**From:** Contact Centre (CRM) <contact@ribblevalley.gov.uk>  
**Sent:** 21 June 2025 12:25  
**To:** Planning  
**Subject:** Planning Application Comments - 3/2025/0356 FS-Case-724859128

**Planning Application Reference No.:** 3/2025/0356

**Address of Development:** 4-5 Brookside, Holden  
Bolton by Bowland  
Clitheroe  
BB74PE

Drawing Title
Proposed Floor Plans And Elevations

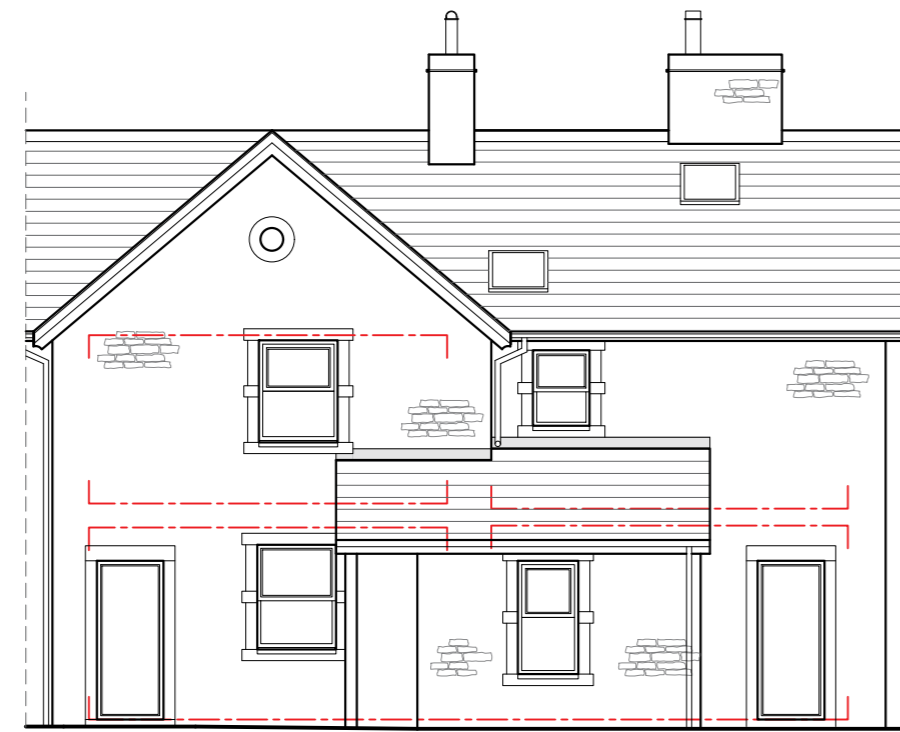
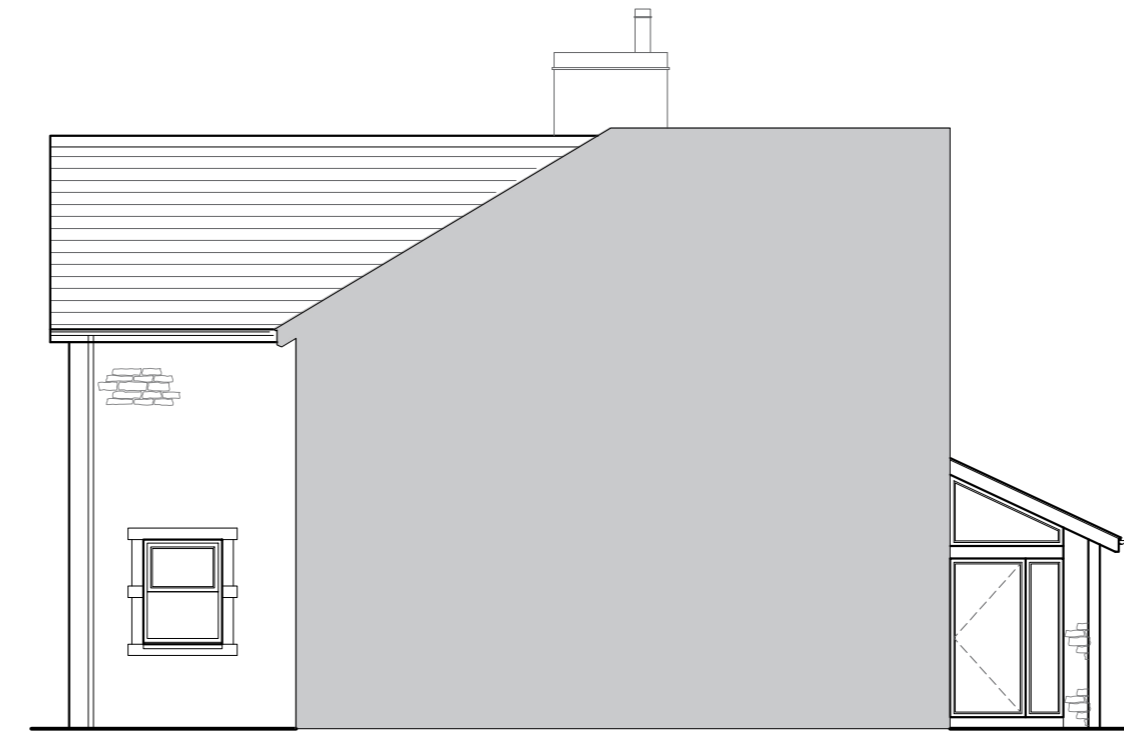
1. The roof in the application says 'slate'. I assume this is an error - the existing roof is stone tiles, and of course this needs to remain the same in line with the attached 1-2 and 3 Brookside.
2. We are particularly supportive of the retrospective planning permission for the front parking area. At a stroke they have solved the parking problems in Brookside, and it is now far safer to drive out to join the main road through Holden. Perhaps you can't fully appreciate this but it is a brilliant solution.
